# **Accessibility Design Review**

St Leonards Health  
Organisations Relocation  
(SHOR)  
Reserve Rd, St Leonards,  
NSW 2065

Prepared by: Daniel Craddock  
Prepared for: Health Infrastructure NSW  
Date: 14<sup>th</sup> November 2017  
Revision: 02

GA PLAN - GROUND LEVEL

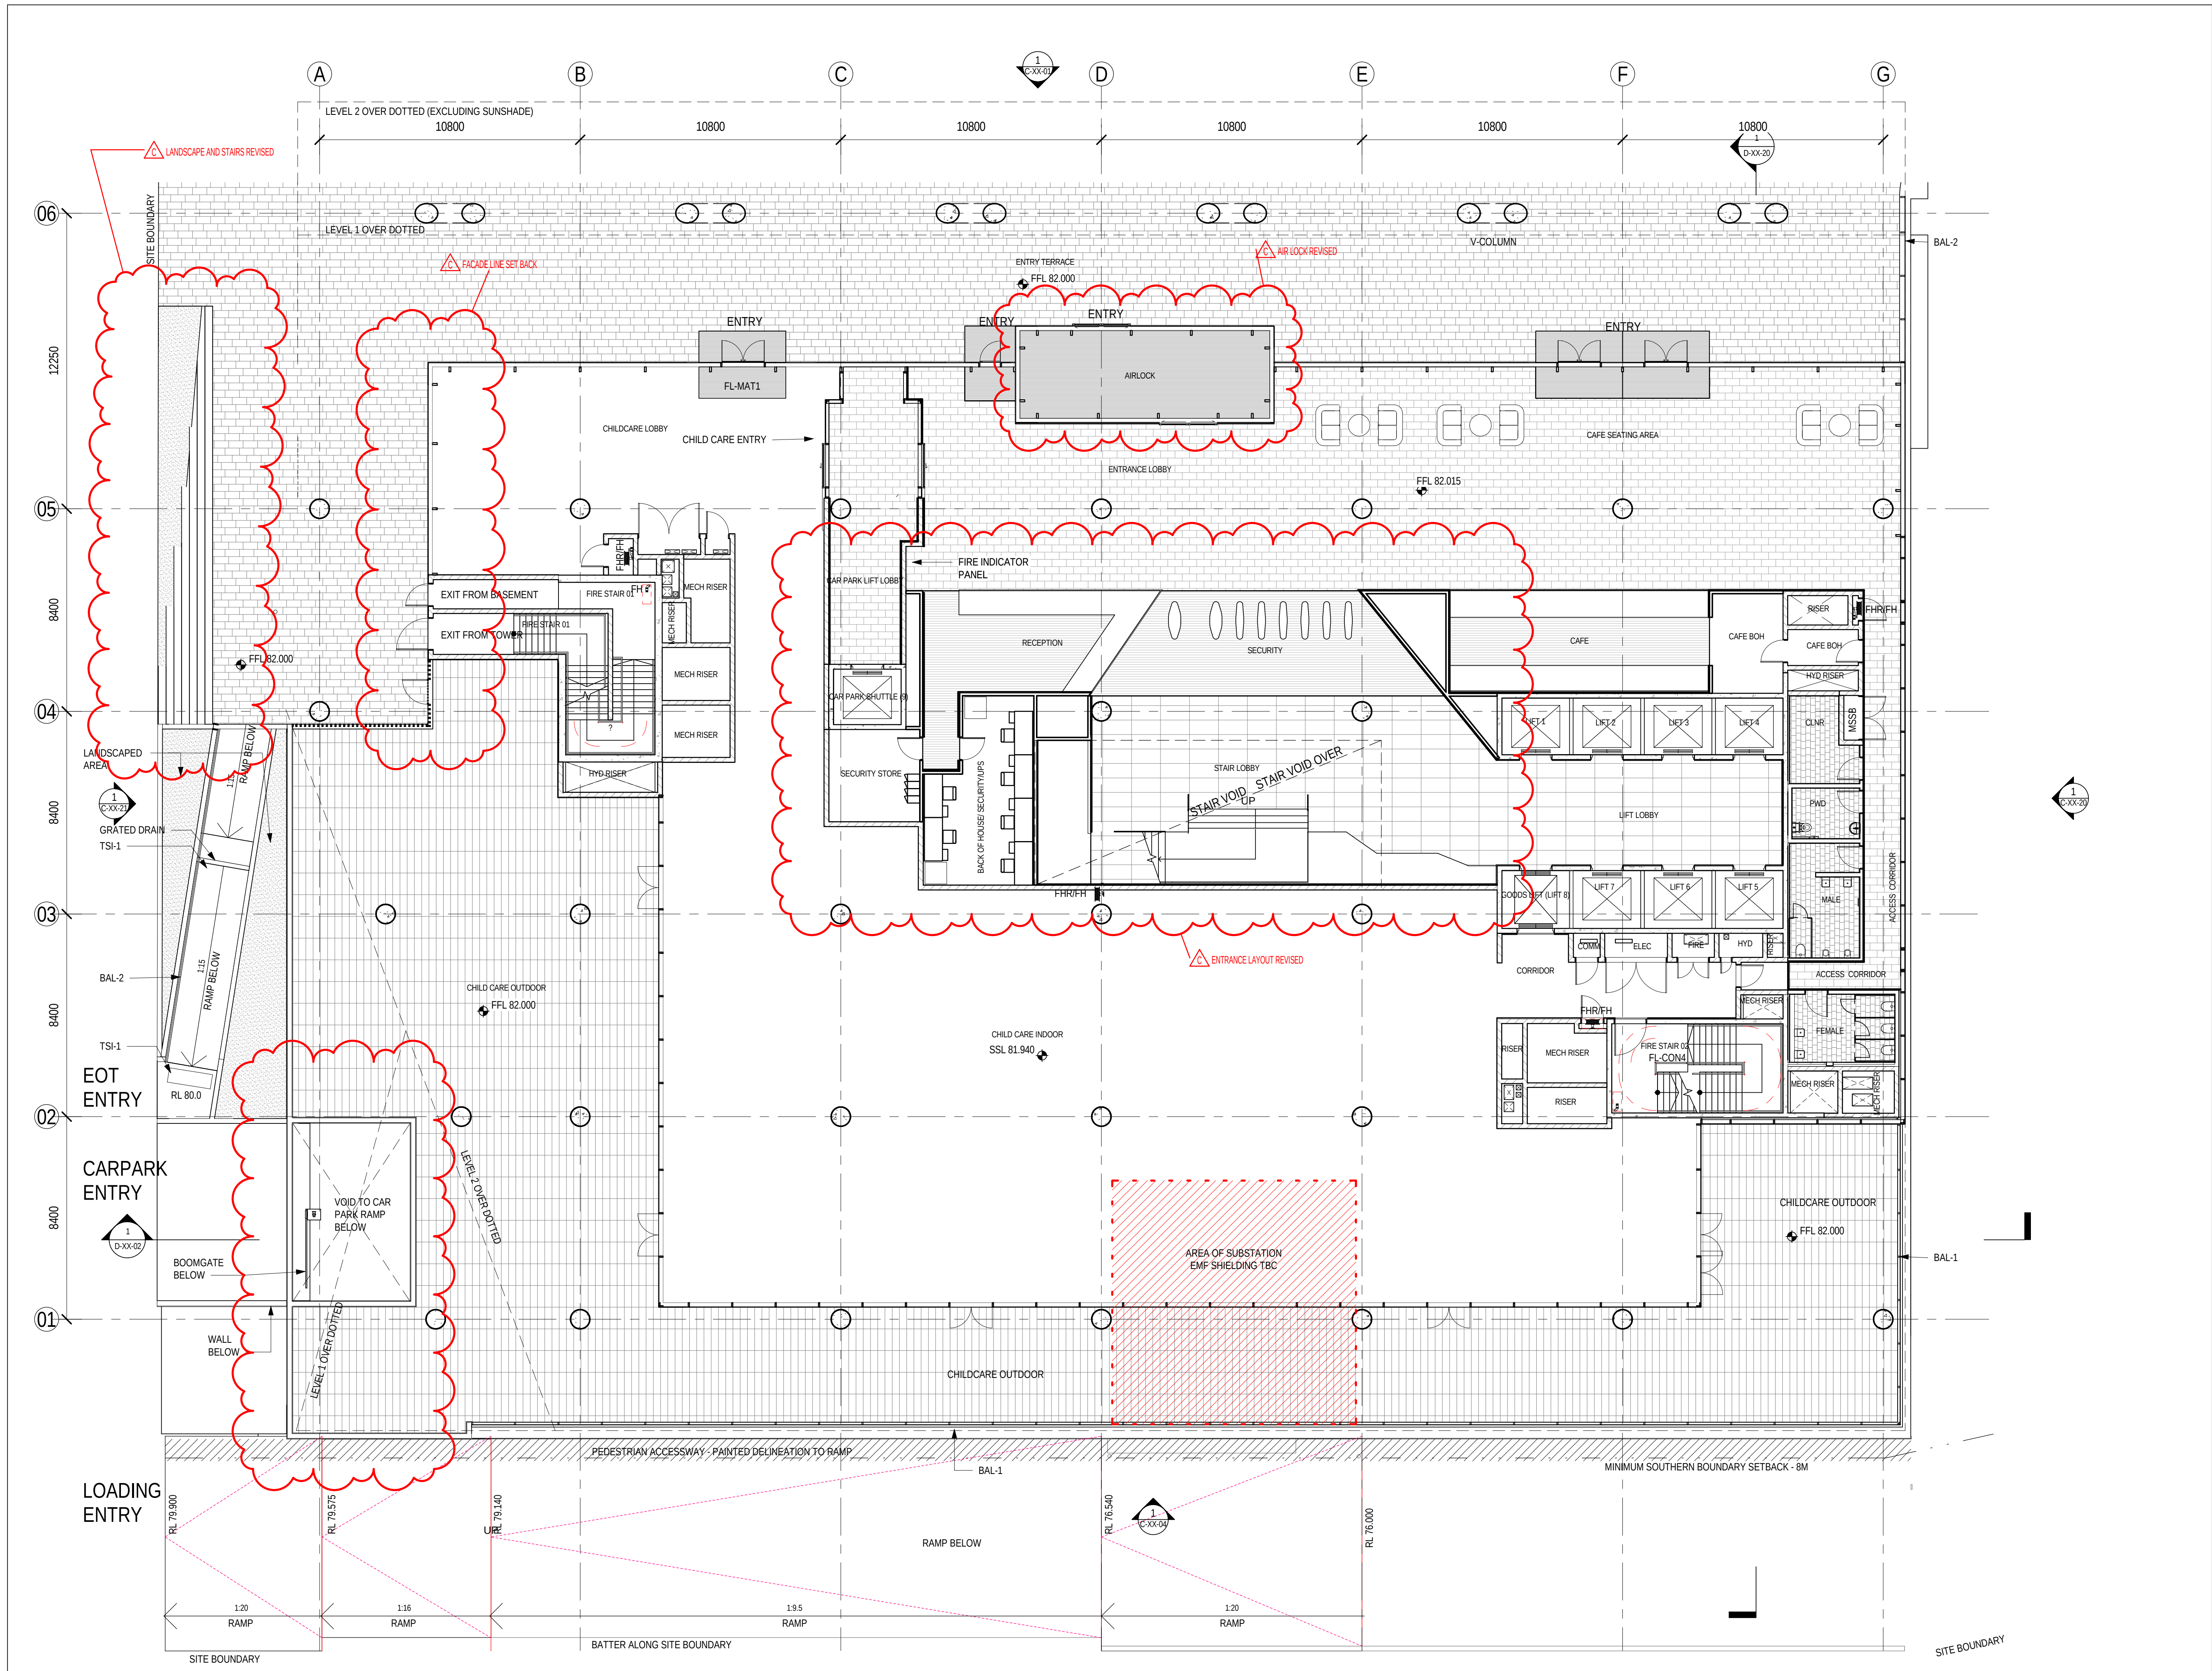
| Comment/issue                                                                                                                                                                                                                                             | Recommendation                                                                                                                                                                                                                                                                                                                                                 | BCA/<br>DDA |
|-----------------------------------------------------------------------------------------------------------------------------------------------------------------------------------------------------------------------------------------------------------|----------------------------------------------------------------------------------------------------------------------------------------------------------------------------------------------------------------------------------------------------------------------------------------------------------------------------------------------------------------|-------------|
| <ul style="list-style-type: none"> <li>Ensure external paths are of an adequate width to accommodate passing and turning spaces</li> </ul>                                                                                                                | <ul style="list-style-type: none"> <li>Compliance indicated at basement level</li> <li>Provide more details to confirm compliance of external paths to the principal pedestrian entrance on ground level.</li> </ul>                                                                                                                                           | BCA         |
